From: T Stevens [REDACTED]
Sent: 08 November 2017 13:57
To: Zac Denton
Cc: [REDACTED]
Subject: RE: R/1/17/T

I have received Arboricultural comments regarding your application for works at various locations across the Poplars and Parklands Estates, Rustington.

PARKLANDS / COWDRAY DRIVE

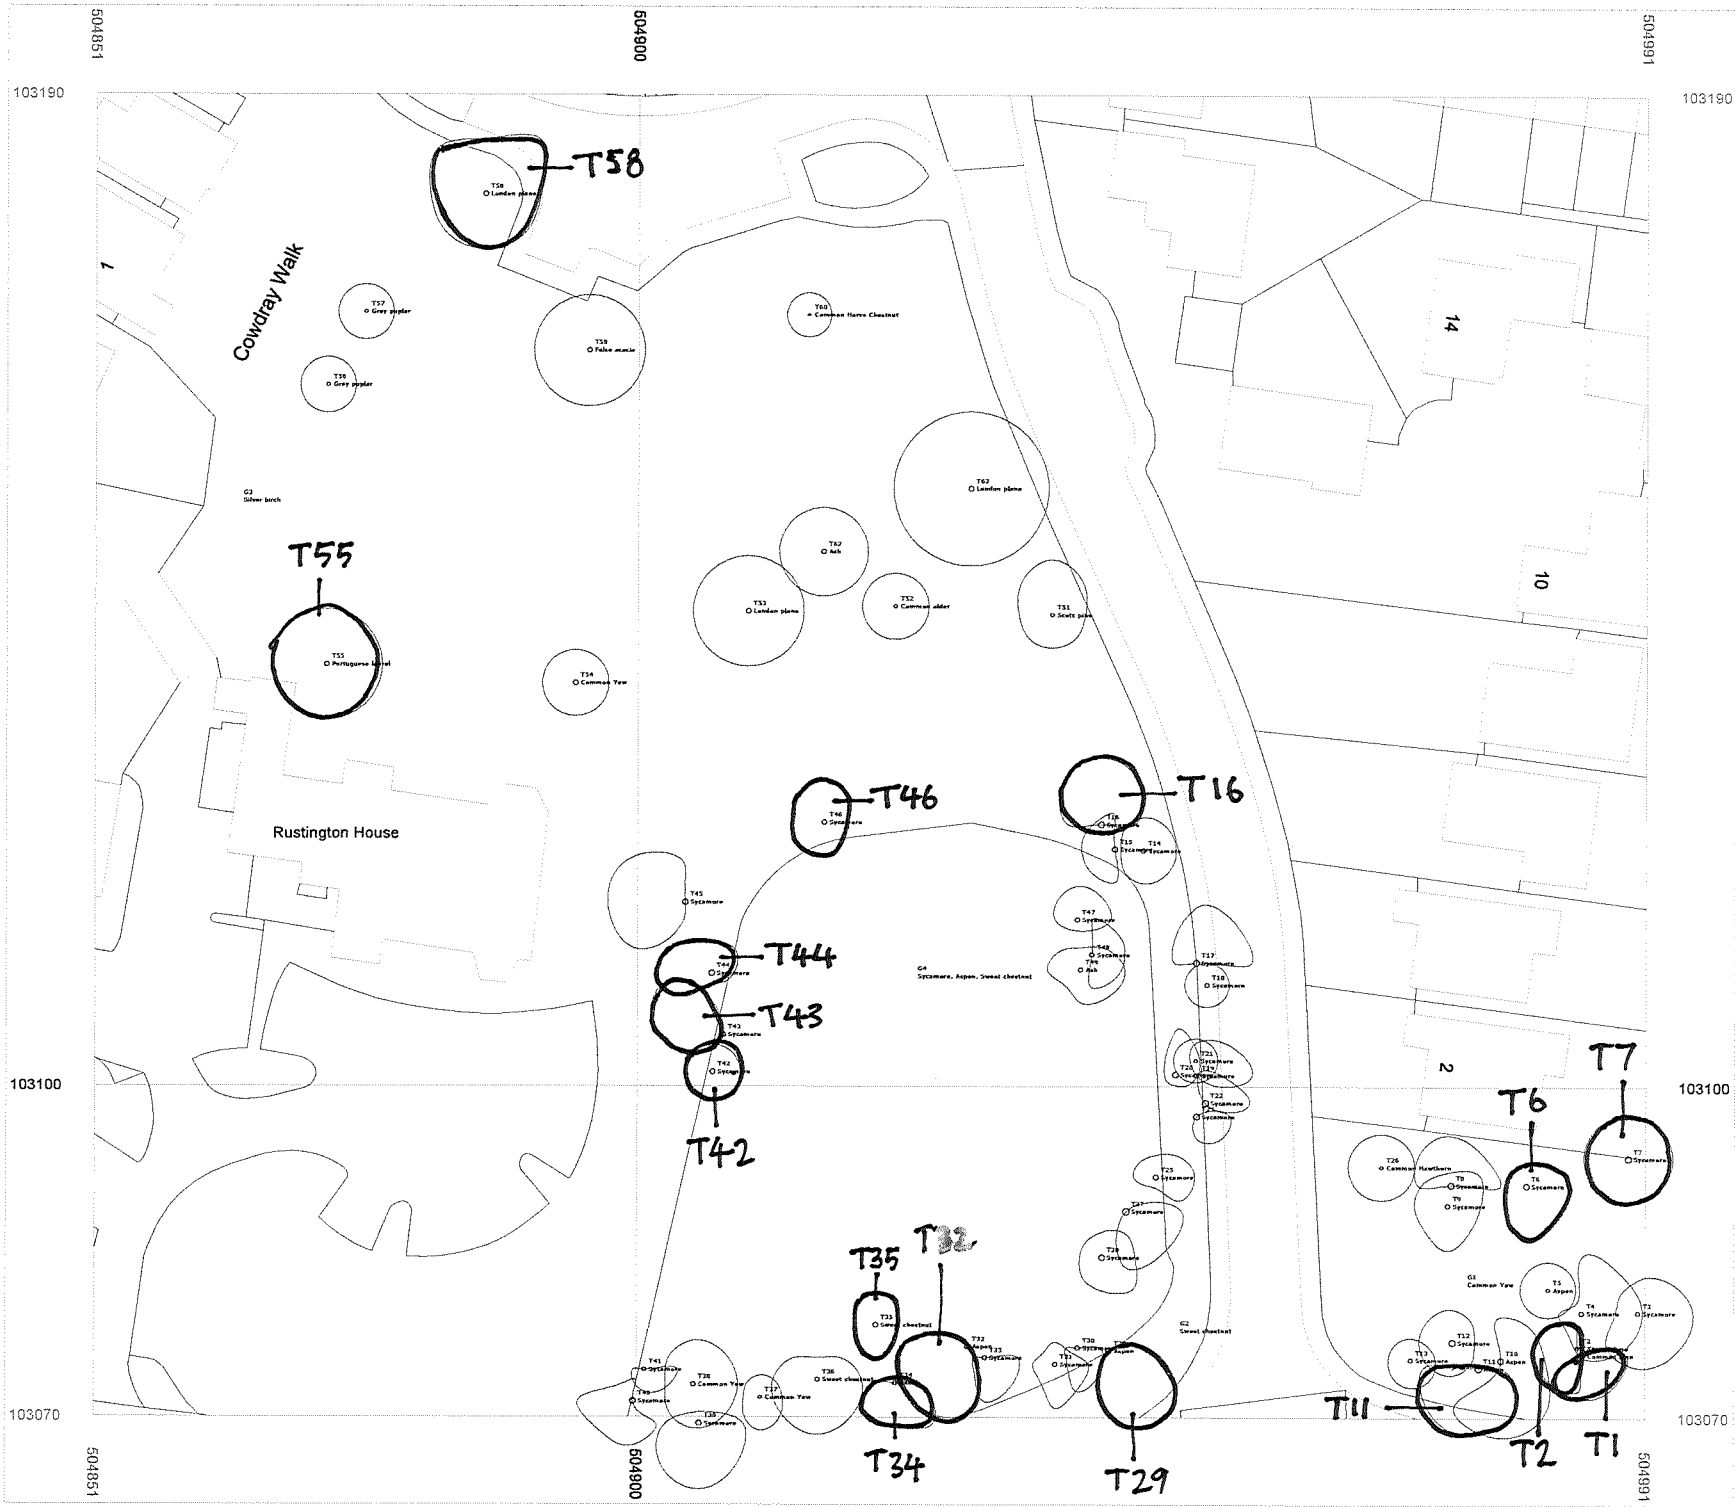
Please confirm that works to T6, T7, T11, T16, T34, T55 and T58 will no longer form part of the application, and will therefore require resubmission.

Many thanks for your email below – we have spoken with the tree surgeon who is advising us on this application and can confirm that we agree to the removal of the works detailed below. In due course we would request further information as to the objection to these works to assist us with any future applications.
